WEST SUSSEX COUNTY COUNCIL CONSULTATION

TO:	Arun District Council FAO: Anita Gardner
FROM:	Highways, WSCC
DATE:	18/01/2018
LOCATION:	Land Rear Of 1 To 6, The Cottrells, Angmering, BN16 4AF
SUBJECT:	A/158/18/PL Variation of condition 1 imposed under A/8/18/PL relating to the substitution of approved plan drawings NO ADC 962 04 rev A & 13 rev B for drawings No ADC 962 20 & 21 (ground & first floor plans & roof plan). This application affects the character & appearance of the Angmering Conservation Area.
DATE OF SITE VISIT:	N/A
RECOMMENDATION:	☒ Advice ☐ Objection ☐ Modification ☐ No Objection ☐ More Information ☐ Refusal
S106 CONTRIBUTION TOTAL:	£N/A

Rev	Description	Date
Job Reference		
New House The Cottrells Angmering, BN16 4AF		Client AM Homes Ltd
Drawing Title Ground Floor Plan		Drawing No ADC962/20
Date 23.11.18	Scale 1:100	Dwg Size A3
Plot Style ADC-red	Drawn TOS	Checked AD

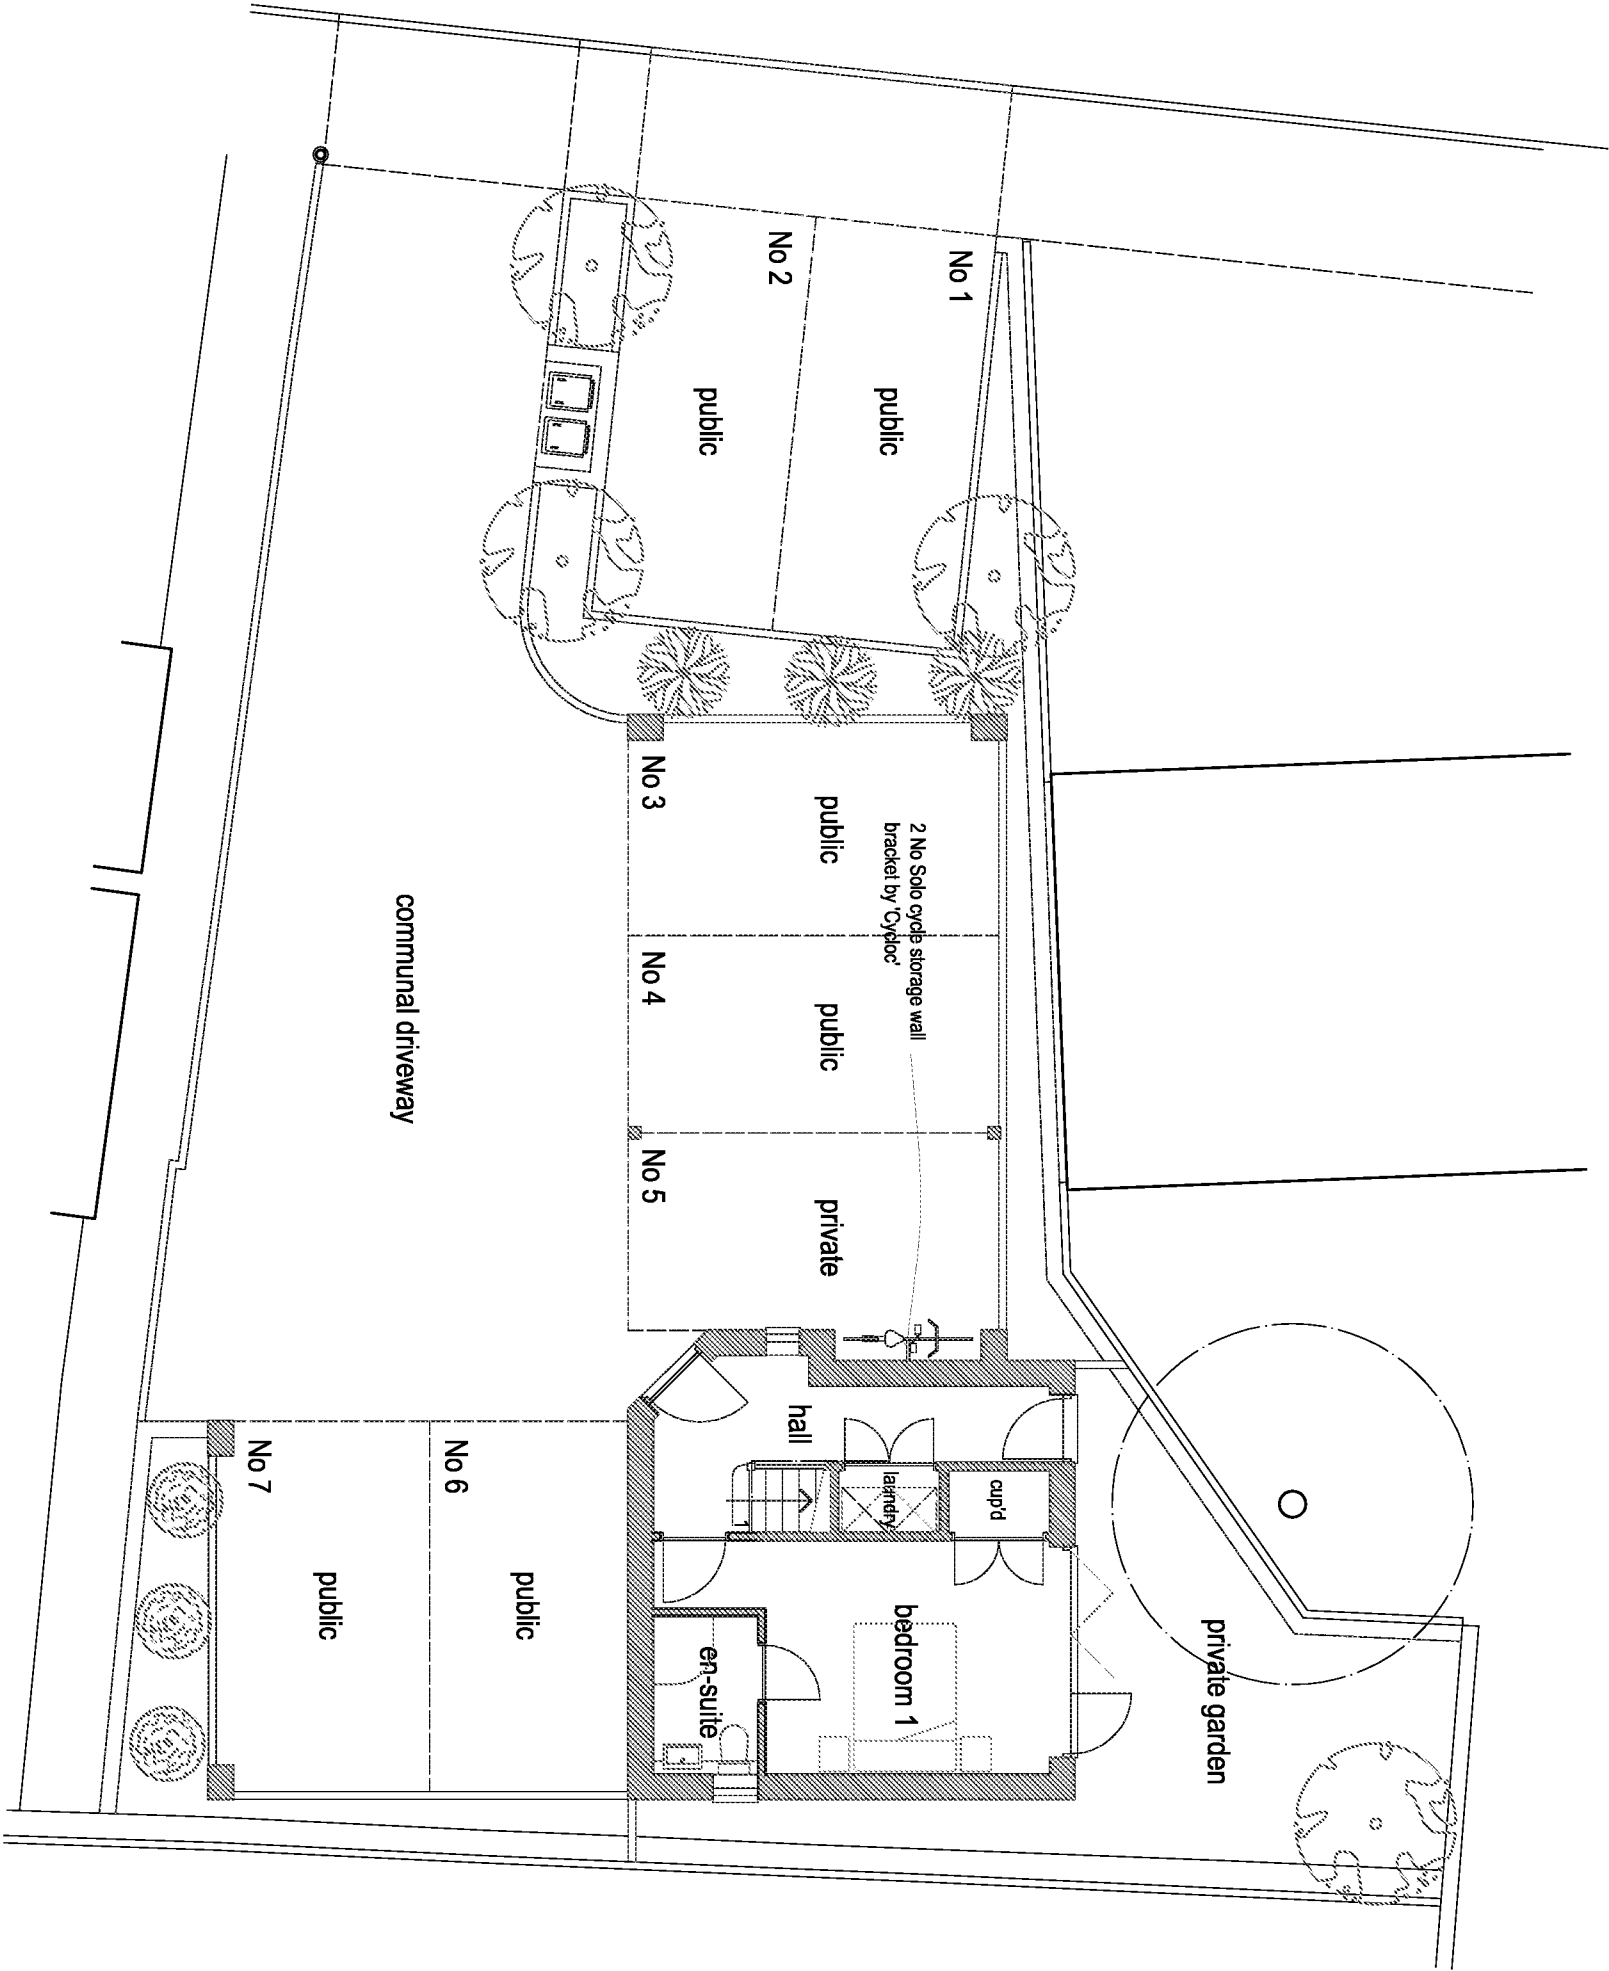
The proposed plans indicate that the master bedroom has been relocated to the ground floor and the kitchen relocated from the ground floor to the first floor and integrated into the living room. As such, the plans indicate that a 'study' has now been provided on the first floor. The proposed alterations still result in a dwelling consisting of four habitable rooms and as such the WSCC parking demand calculator still anticipates that one parking space is sufficient. Any overspill parking resulting from the reconfiguration of the dwelling is an amenity issue and the LPA may wish to consider this from an amenity point of view.
